**Our ref:** SL/2023/122661/04-L01  
**Your ref:** EN010128  
**Interested party ref:** 20049138  
**Date:** 26 November 2024

### **Environment Agency Written Representation for the Development Consent Order (DCO) for the Cory Decarbonisation Project PINS Reference: EN010128**

ENVIRONMENTAL STATEMENT: 6.3 APPENDIX 11-2: FLOOD RISK  
ASSESSMENT, Cory Decarbonisation Project, PINS Reference: EN010128,  
September 2024

Revision P01

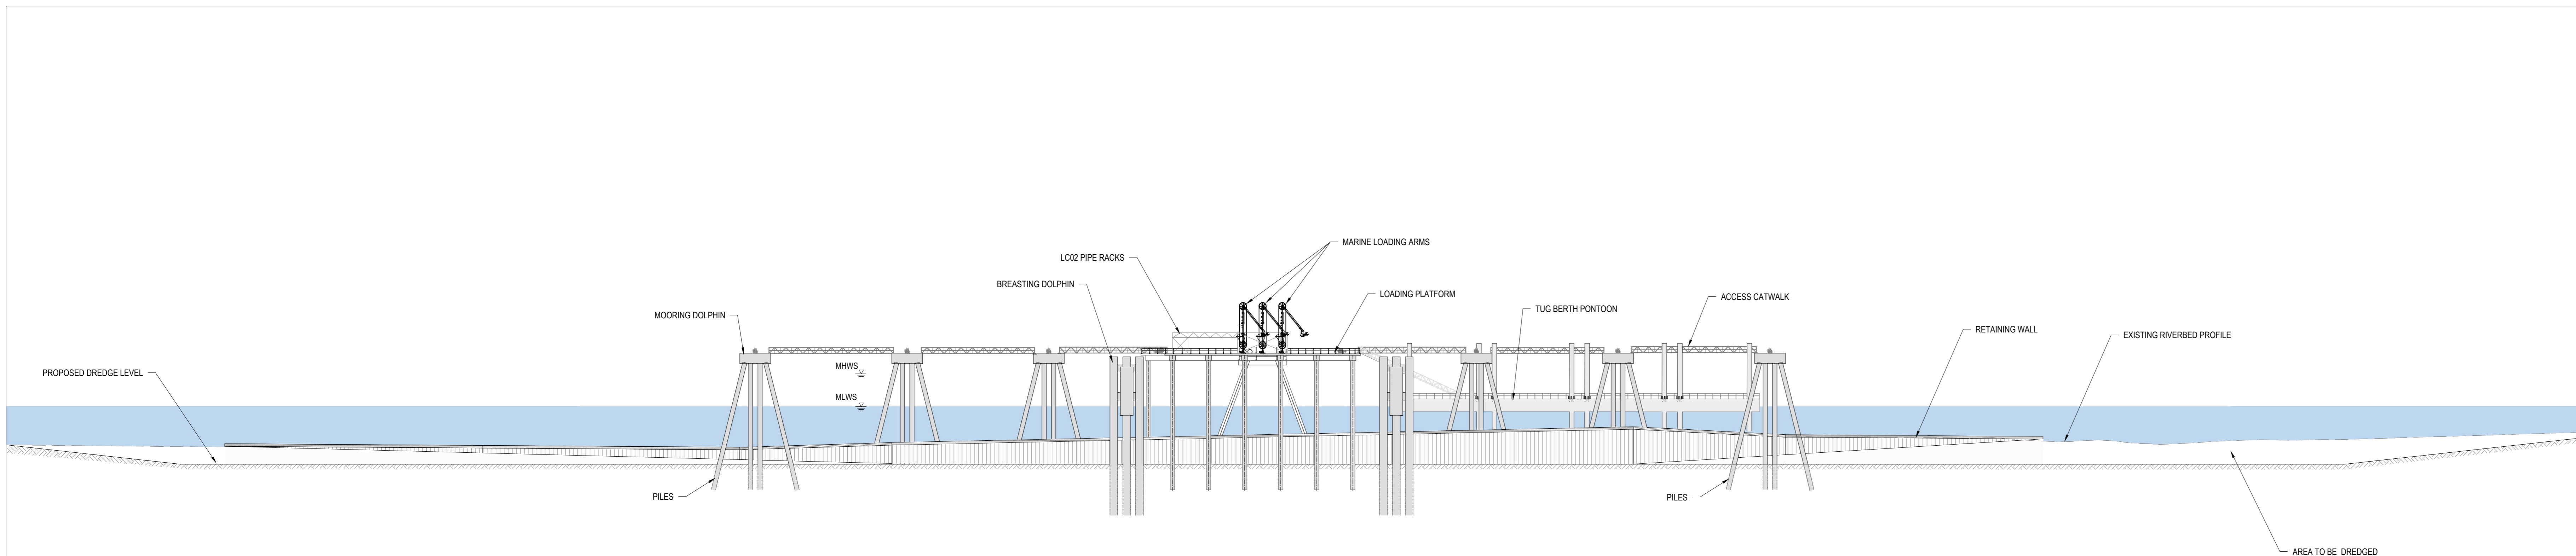
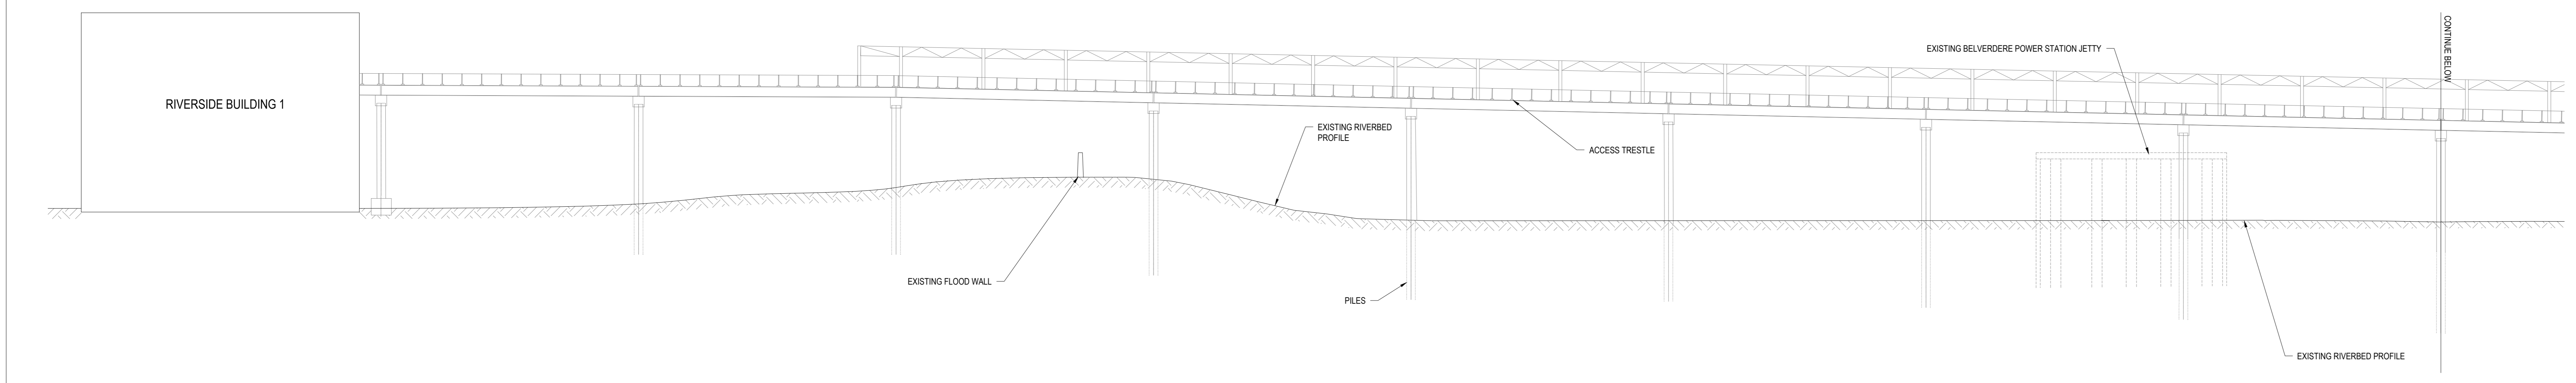
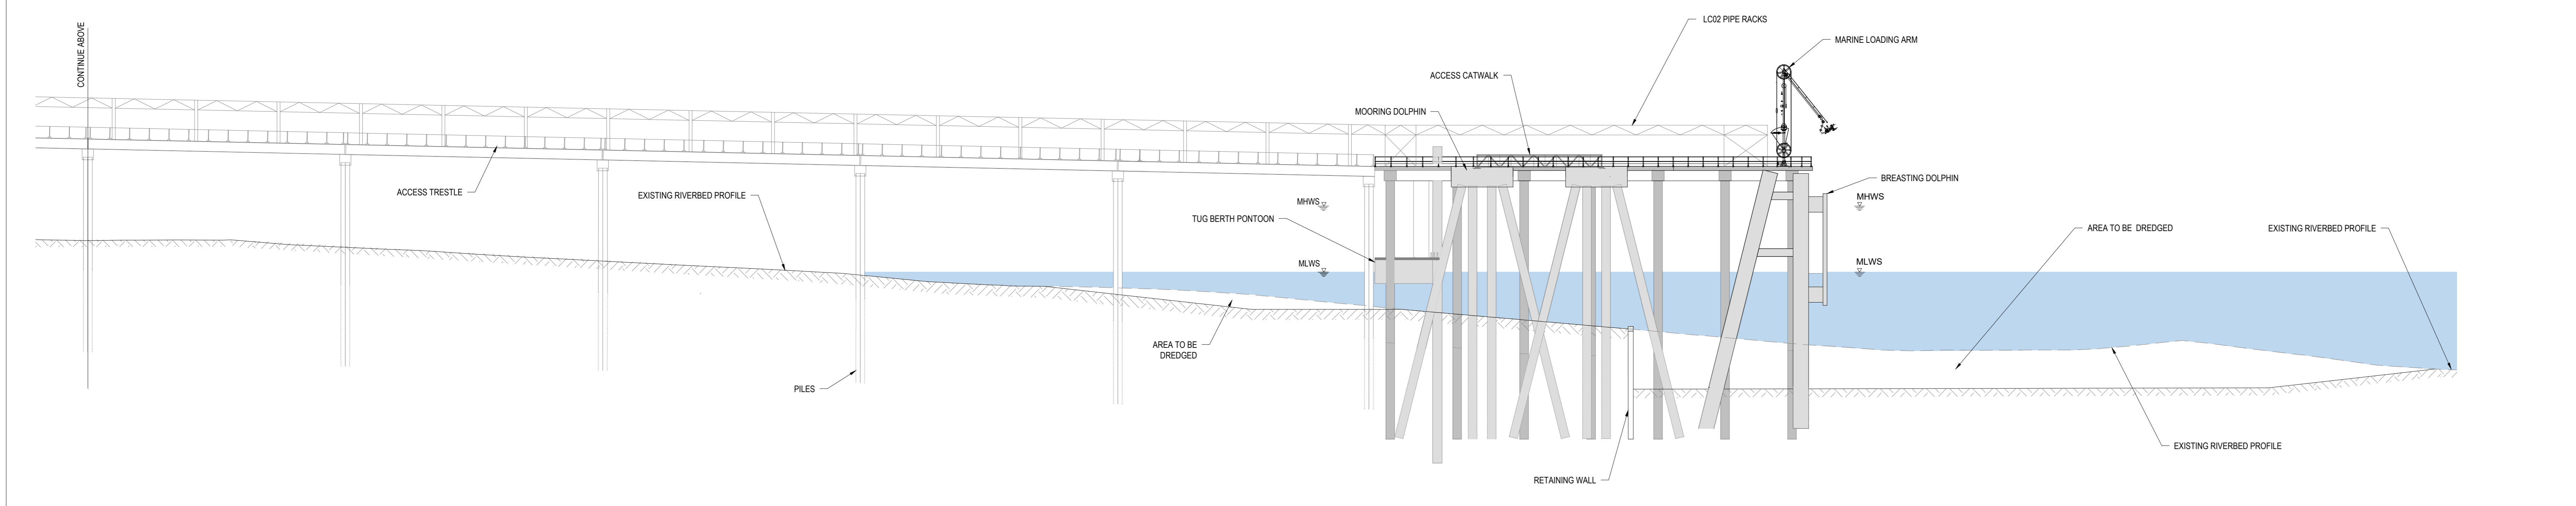
5.1. 12 The biggest factor in setting the clearance that any jetty should over sail the flood defences by is the space required for future works. The existing Middleton Jetty was required to respect a 5-metre vertical clearance.

The Applicant's response to our challenge over whether the new jetty has been represented well enough in the modelling does not answer the point about the design of the jetty only refereeing to its location. None of this can be resolved before a sound modelling approach has been substantiated.

Figure 5-7: Scenarios 1 and 3 – Difference in Predicted Sedimentation (m)

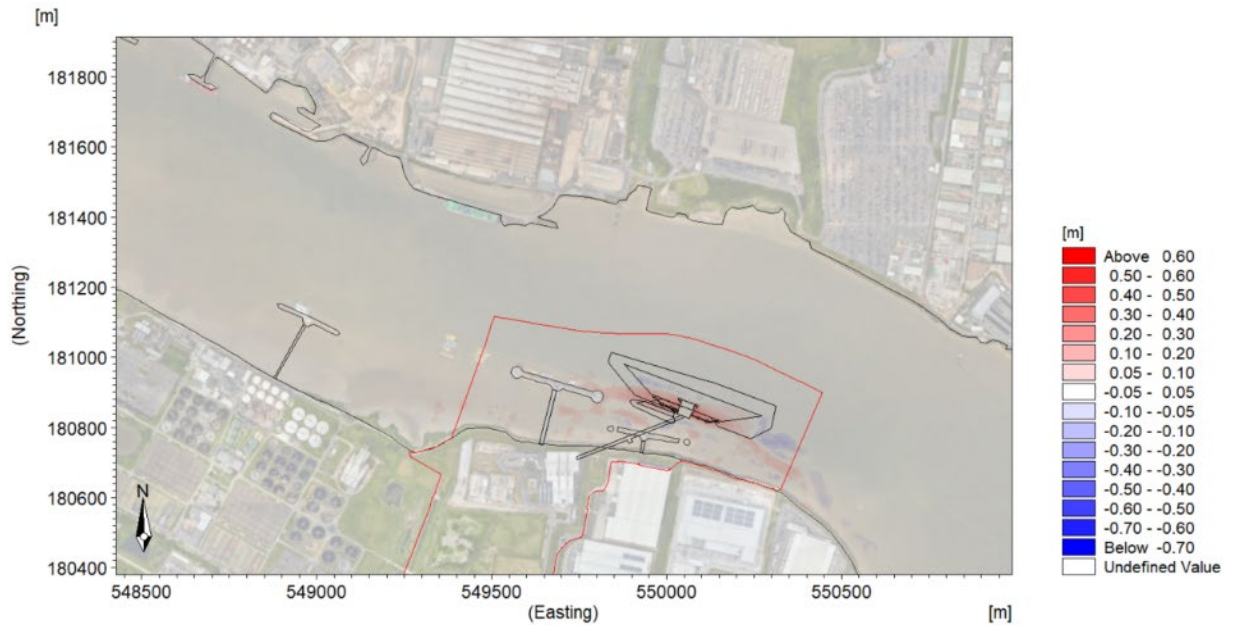
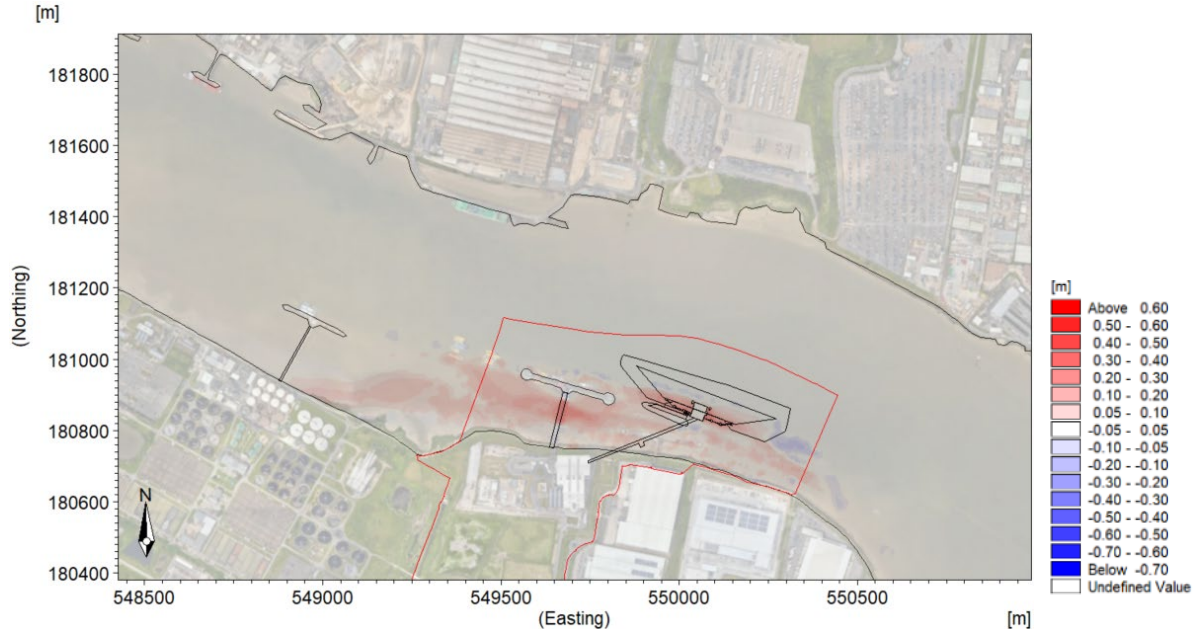
5. 1. 17 We have questioned the soundness of the applicant's coastal process assessment modelling including results appearing to be counterintuitive relative to the change being assessed. The development team have acknowledged our challenge questions by e-mail, and we are waiting for their response. Changes to sediment transport could impact surface water outfalls and the sustainability of vessel berths.

5.1. 19 The coastal process modelling evidence remains in doubt and the Environment Agency disagree over the need to address the risk of sediment build up at the Great Breach pumping station outfall.
